Date: 11/14/2024

Re: **Overhanging Sill Plate**
Location: Lot 59 Wellers Knoll (190 Wild Turkey Way, Lillington, NC)
JDS Project No.: RDU2411339
Date of Inspection: 11/14/24

D-1
MONO SLAB
FOUNDATION DETAILS

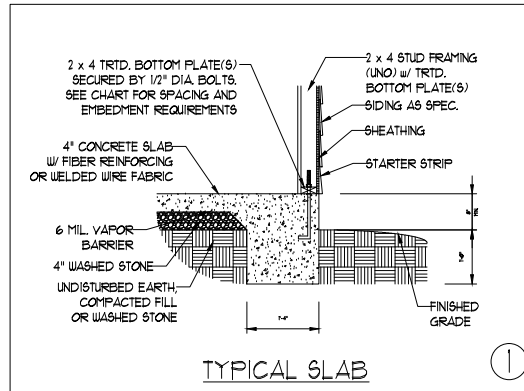
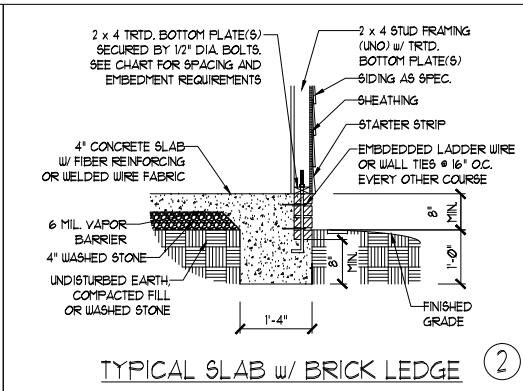
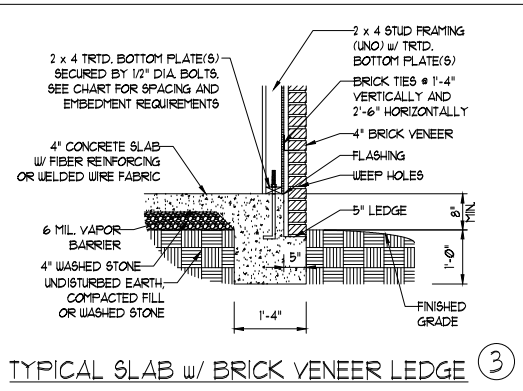
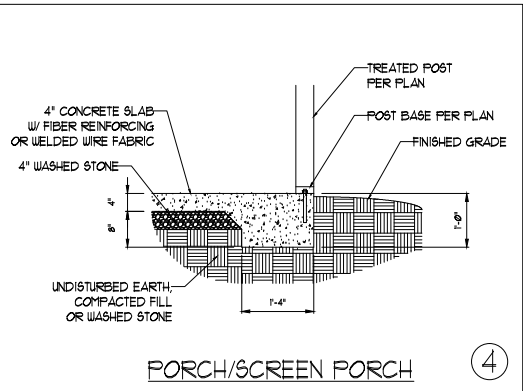
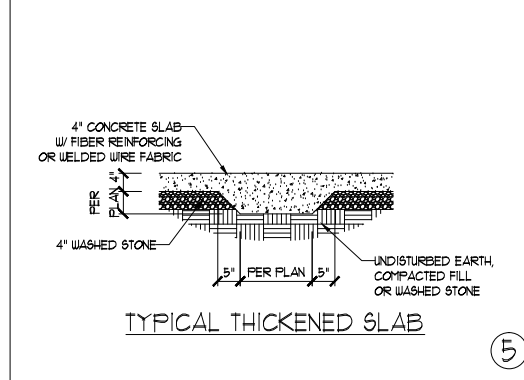
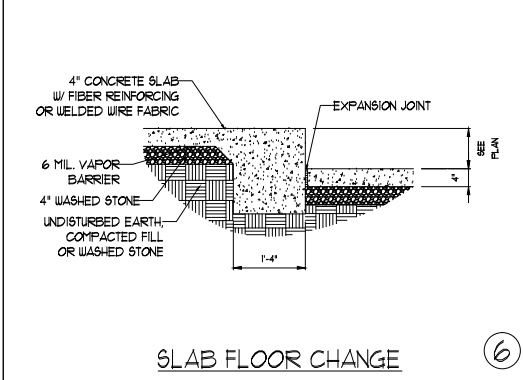
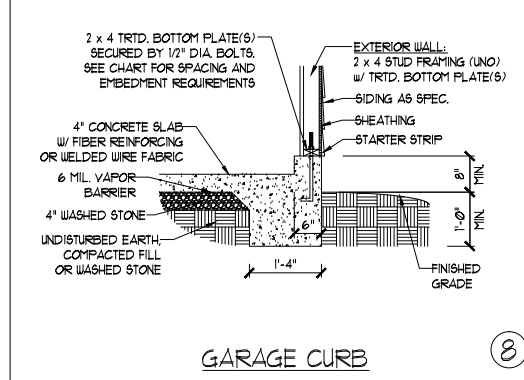
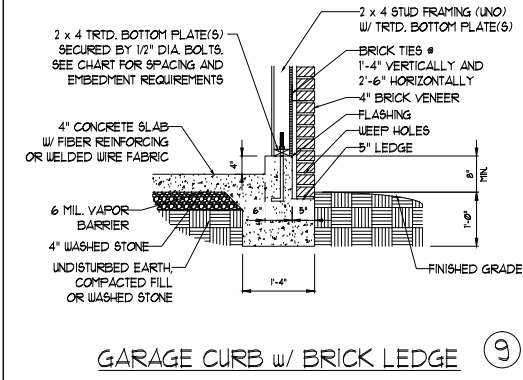
The client requests an evaluation of the left rear corner of the garage walls, the 2x4 sill plate is overhanging on both walls by approximately 1/2". It was observed that the contractor has parged over both the left and the rear garage walls. Client was instructed to remove the parging.

Based on our on-site observations and review, after the concrete has been removed, where the overhang of the sill plate exceeds 1/2" install a treated 2x6 on edge cut to fit tightly between the bottom of the sill plate and the top of the garage slab attached to the face of the foundation with (1) row of 1/2" x 5" Simpson Titen HD screws at 12" o.c. placed 2" from the top of the foundation
